RE: Juan Tabo Hills Estates Preliminary Plat, Project # 1005278

The purpose of this letter is to explain how the comments as contained in the DRB Official Notice of Decision (May 21, 2015) have been addressed. The following items have been revised and are being re-submitted for review and approval.

AS BUILT INFORMATION	
CONTRACTOR	DATE
MARK GOODWIN & ASSOCIATES, P.A.	06/14
INSPECTED BY	DATE
DMG	06/14
ACCEPTANCE BY	DATE
DMG	06/14
REVISIONS	DATE
DMG	06/14
DATE	DATE
06/14	06/14

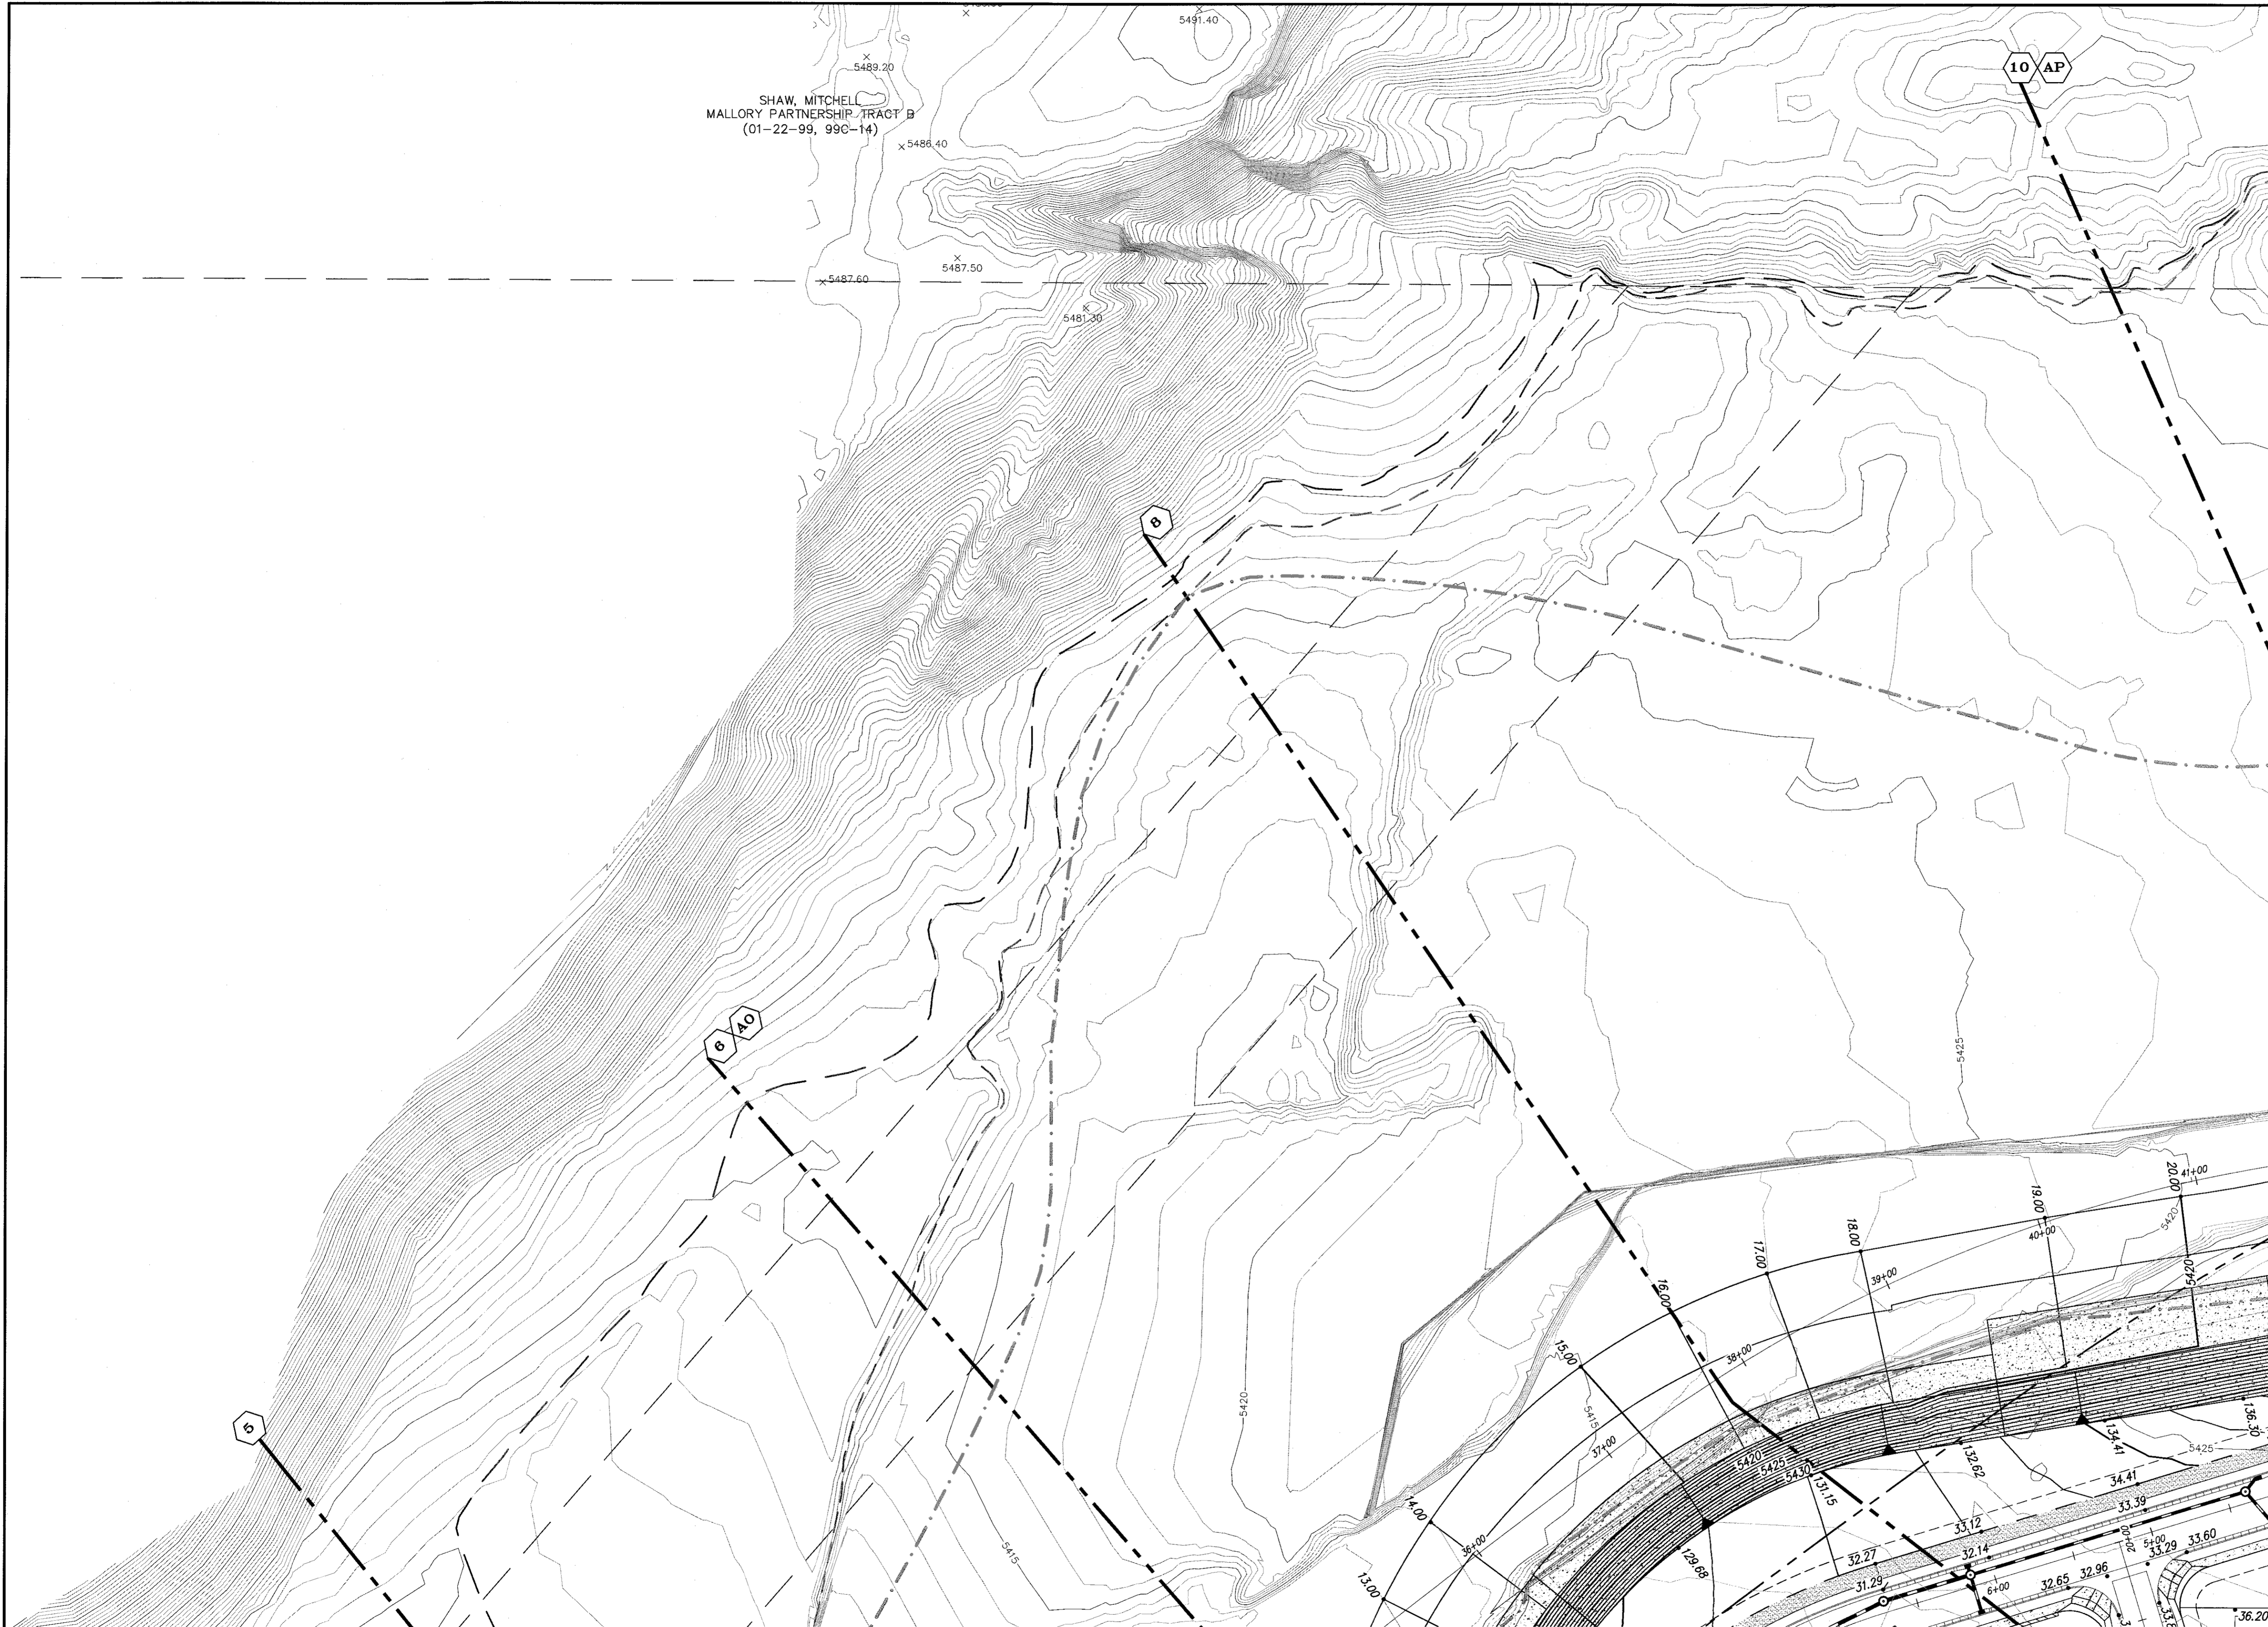
Parks and Recreation comments (1.) requesting changes to the landscape plan are now not applicable since the Landscape Plan and Tract A have been deleted from the site plan, though some separate exhibits have been provided to Carol Dumont to aid in her review. (2.) Previous agreement(s) say that the privately maintained Neighborhood Park is a private park which will be owned and maintained by the HOA. The private park is not subject to City review and approval and so has not been added to the infrastructure List (3.) The signature block on the infrastructure list has been changed to read Parks and Recreation Department. (4.) The Memorandum of Understanding between the USACE and the NMSHPO was distributed to DRB members during the first DRB meeting which outlines the approved plan of action for compliance with all cultural resource regulations (federal, state and local). (5.) The underground utilities are on the Infrastructure list and an updated copy of the Conceptual Utility Plan has been provided to aid in the review of the Infrastructure List. Contours and spot elevations have been

added to the Grading Plan. Separate permits will be obtained from the Corps of Engineers and AMAFCA that will address fencing along the arroyo. (6.) Ten foot wide AC Trails have been added to tracts H and J and are located in the best place available to insure privacy of the residents. AMAFCA has no objection to the approval of the Preliminary Plat and will be reviewing more detailed plans after Preliminary Plat Approval keeping in mind federal water quality standards and regulations.
